St Marys Intermodal Project (SSI 7308)

I refer to the meetings held on 24 March 2021 and 26 March 2021, along with your correspondence dated 29 March and 10 May 2021 regarding condition D16 of SSD 7308. I thank you for your response to the Departments earlier review and comments.

Figure 3 Noise Barrier (blue)

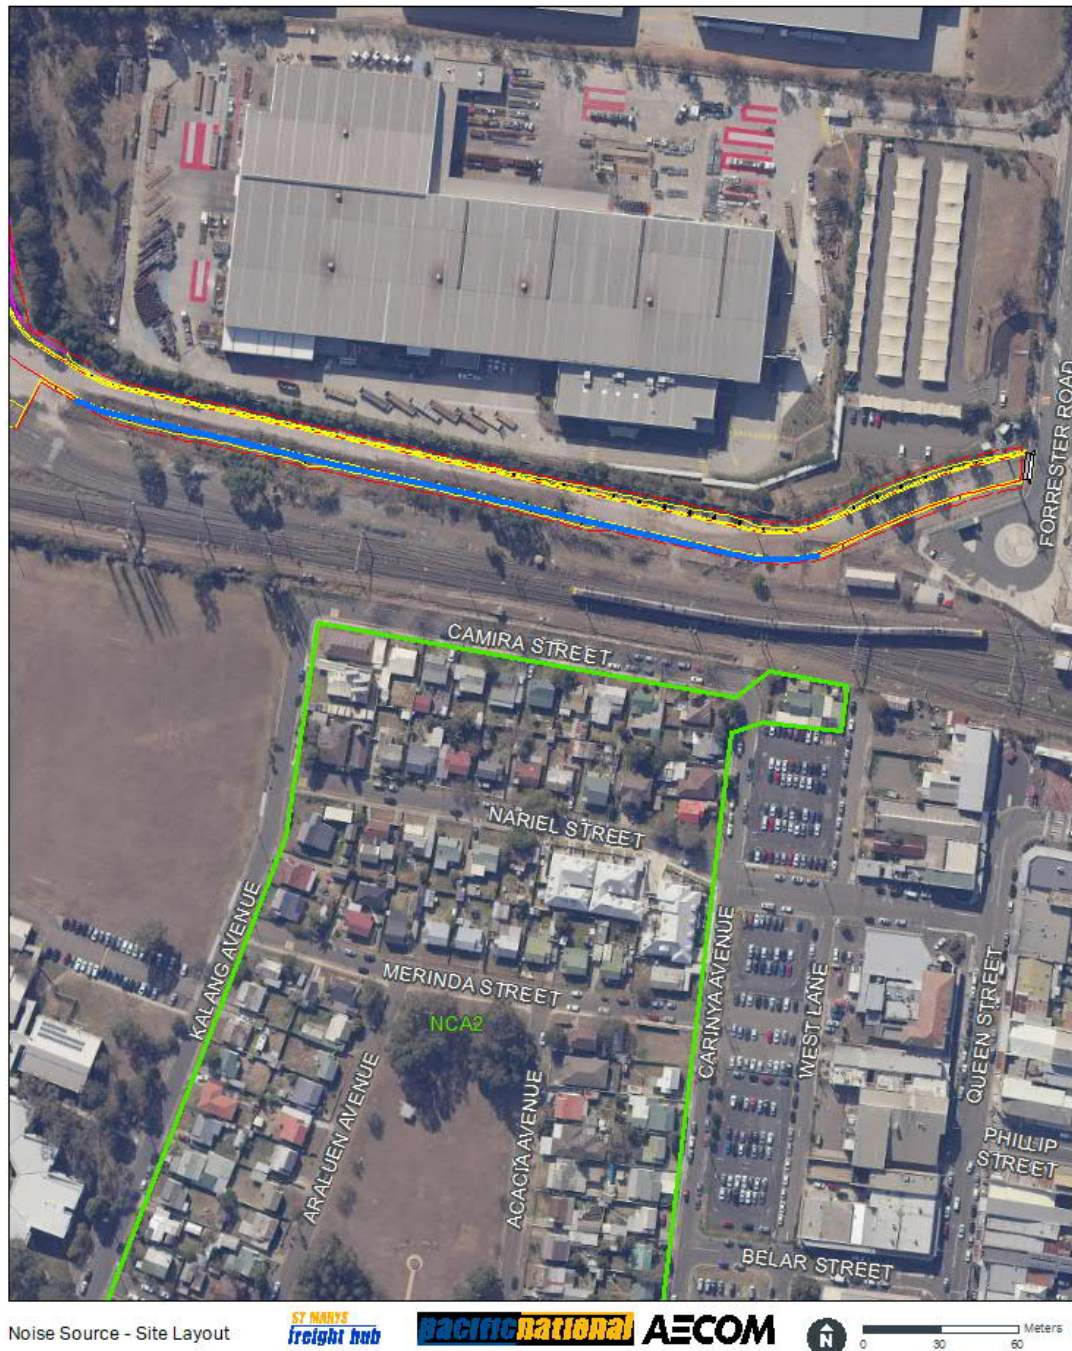
After careful review of the correspondence provided, we note that you are making best endeavours to seek Sydney Trains' agreement on the noise barrier's design and construction. I encourage you to continue to work closely with Sydney Trains to obtain an agreement on the design, construction, and maintenance of the noise barrier.

Should an agreement not be met before the commencement of operation of the site, you may seek the Planning Secretary's agreement for an alternative timeframe for the building and implementation of the noise barrier. The request is to include the following information:

- an interim approach to reduce noise impacts associated with the operation of the site that provides for temporary at source and barrier treatments;
- noise modelling demonstrating that the interim approach would result in reducing noise that is generally in accordance with the EIS, RtS, and post-RtS predications, including those outlined in *St Marys Freight Hub – Updated Noise and Vibration Impact Assessment – Noise Barrier Locations* (dated 8 July 2020);
- a timeframe for finalising the agreement with Sydney Trains to design and construct the noise barrier.
